National Highways Planning Response (NHPR 21-09) Formal Recommendation to an Application for Planning Permission

Council's Reference: 21/03267/OUT

Location: OS Parcel 0006, southeast of Baynards House Adjoining A43, Baynards Green

National Highways Ref: 92857

BOUNDARY SECTIONS 11-15

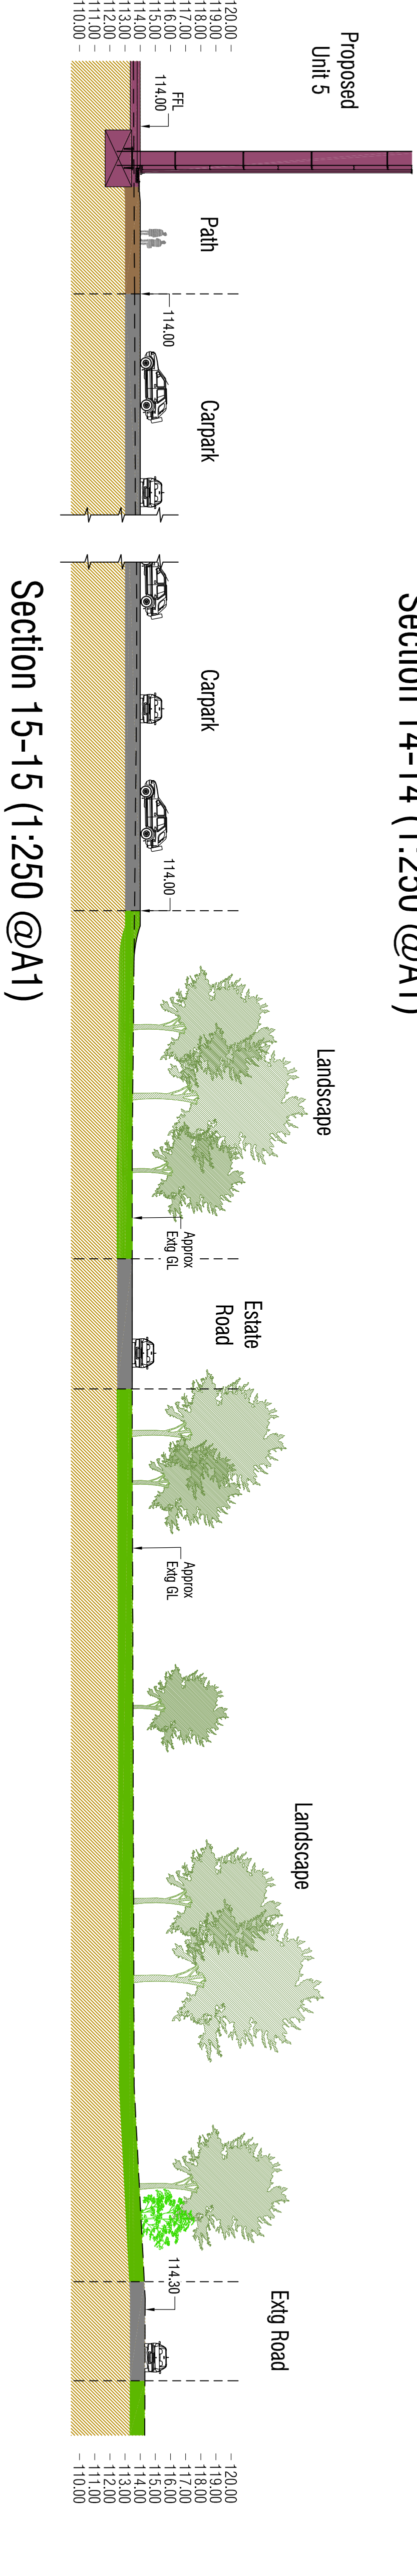
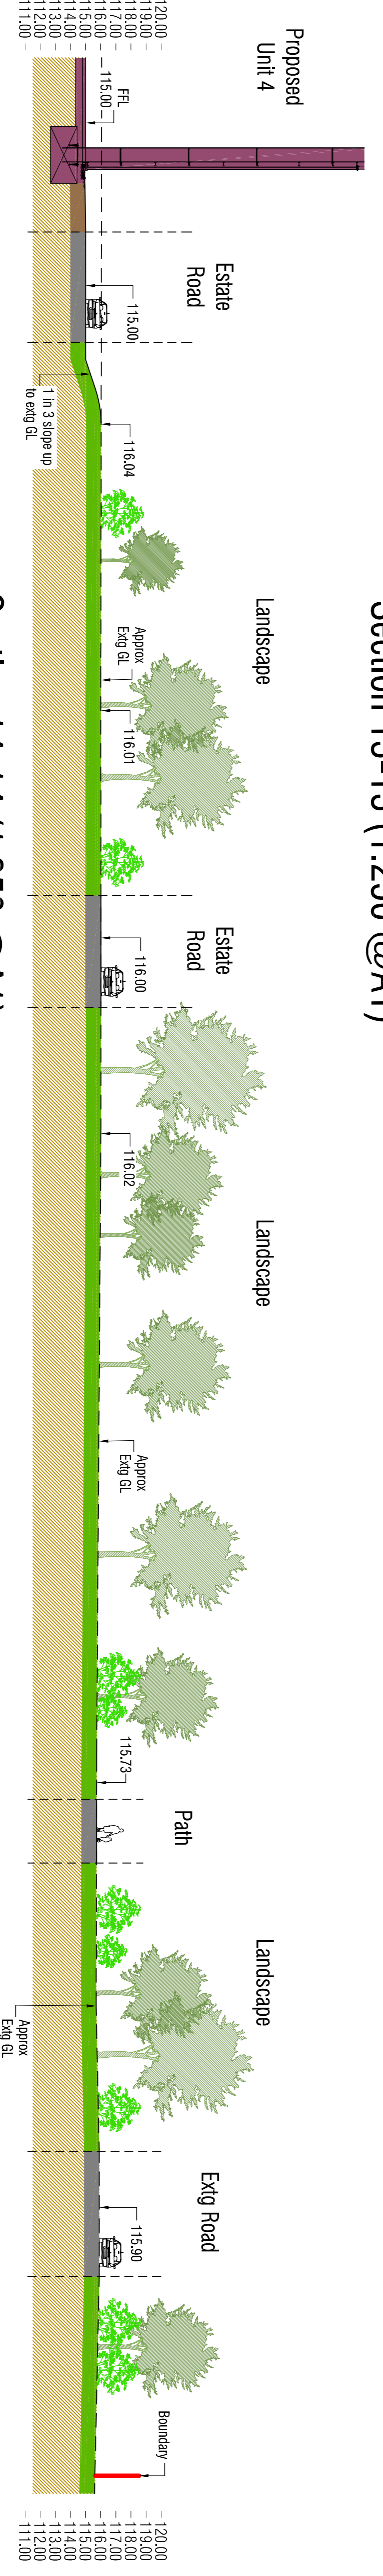
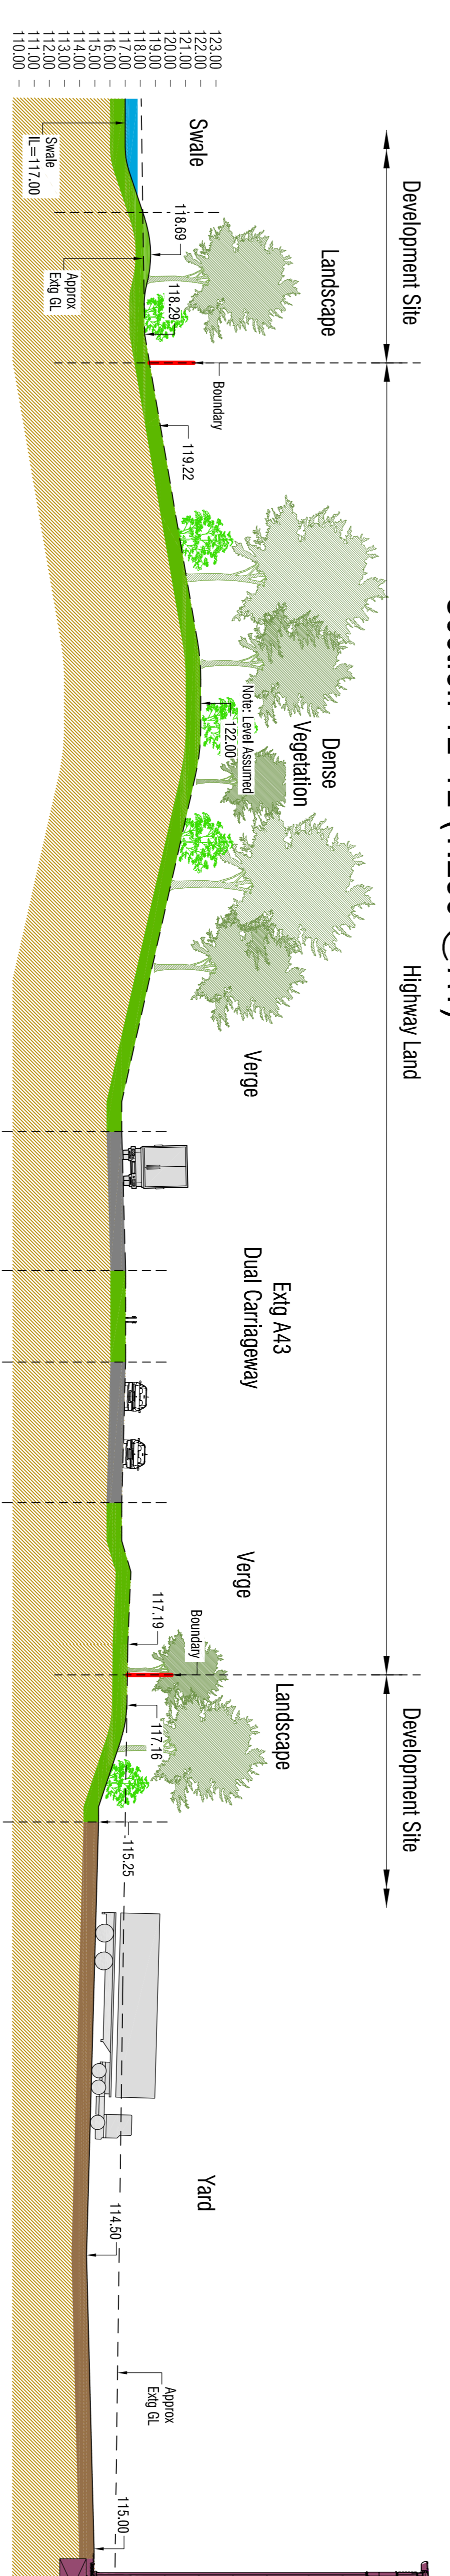
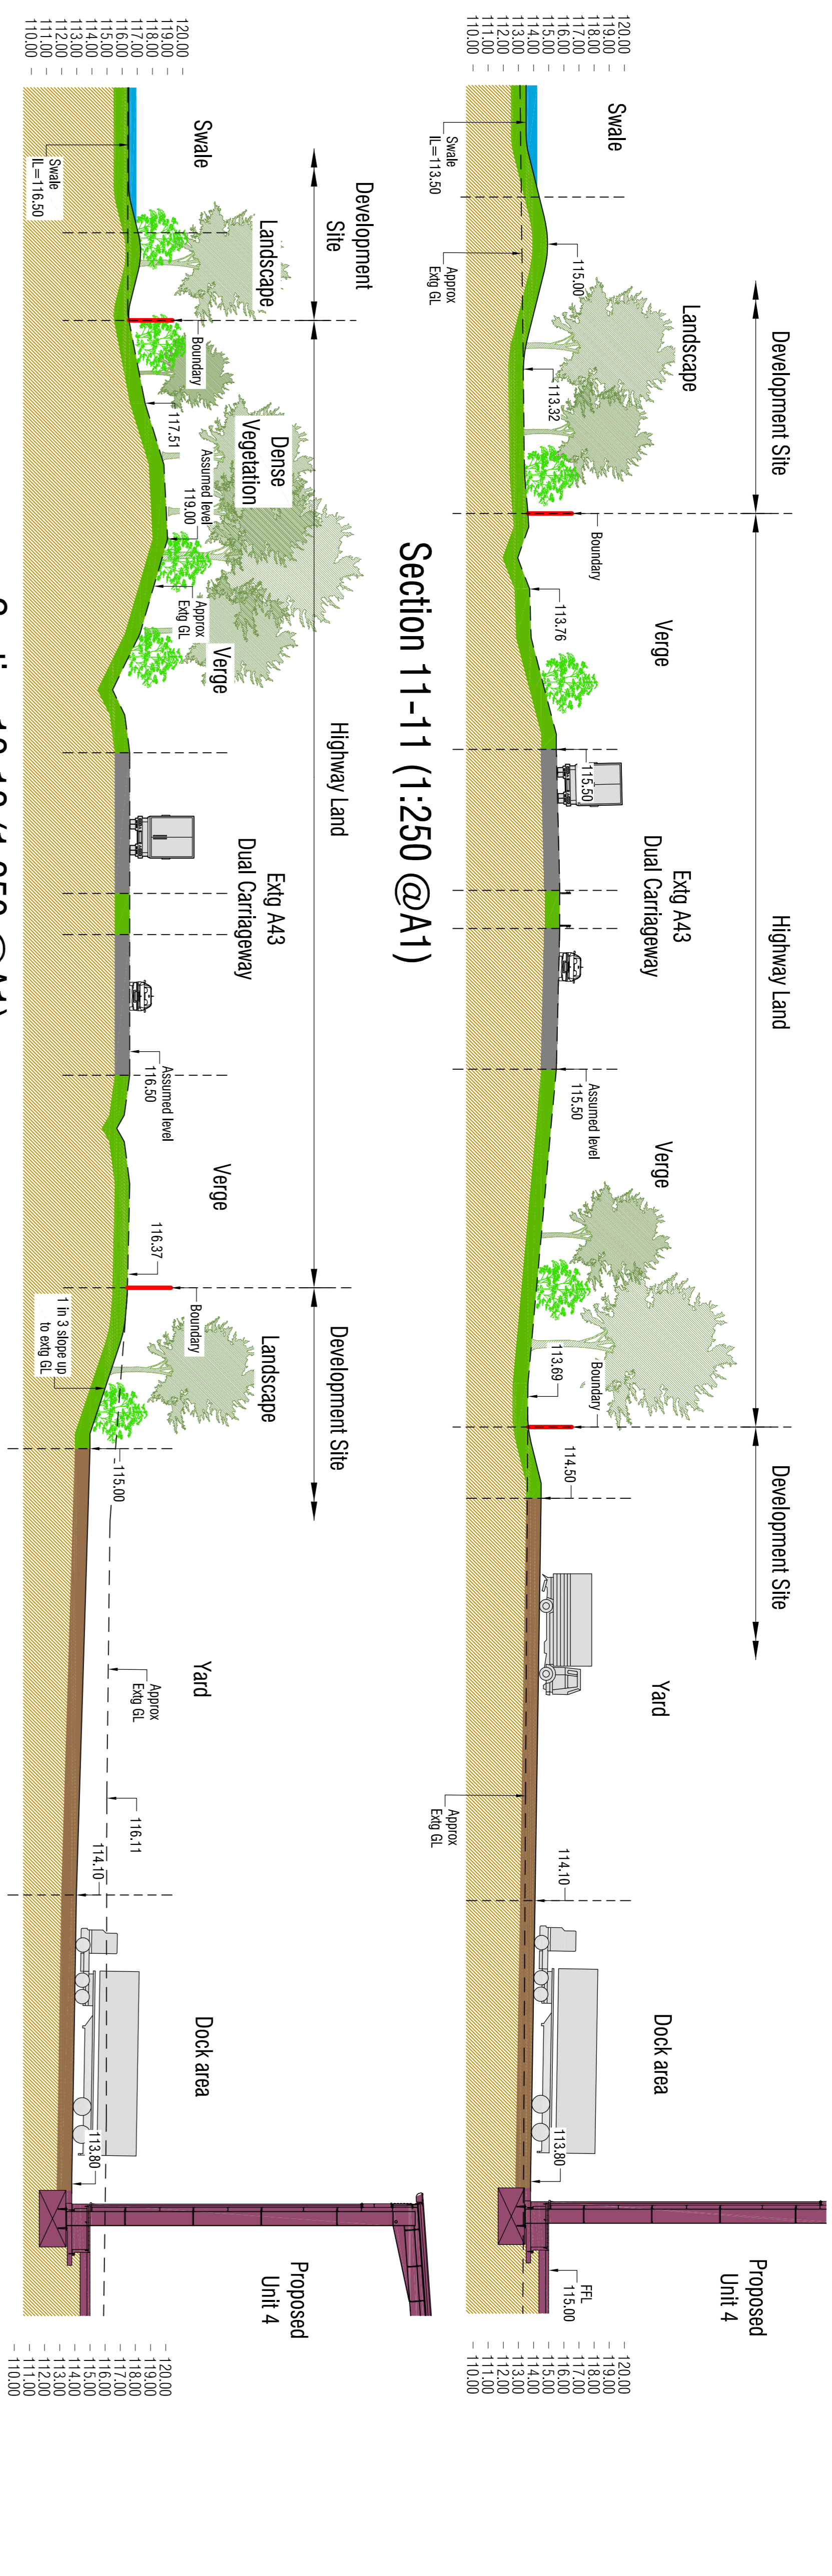
The applicant will need to advise / confirm if there will be any earthworks associated with the development(s) in relatively close proximity to National Highways boundaries (e.g. the stability of the balancing ponds, etc). In the first instance, some cross sections (to scale) through the boundaries showing the proposed extent of the development, its features and any proposed changes in elevation (excavations, landscaping) etc should be submitted for further assessment. Once received, we will review to determine the possible extent of any geotechnical reporting under the Design Manual for Roads and Bridges (DMRB) standard CD 622, which may be required to confirm the extent of any geotechnical risk to the SRN.
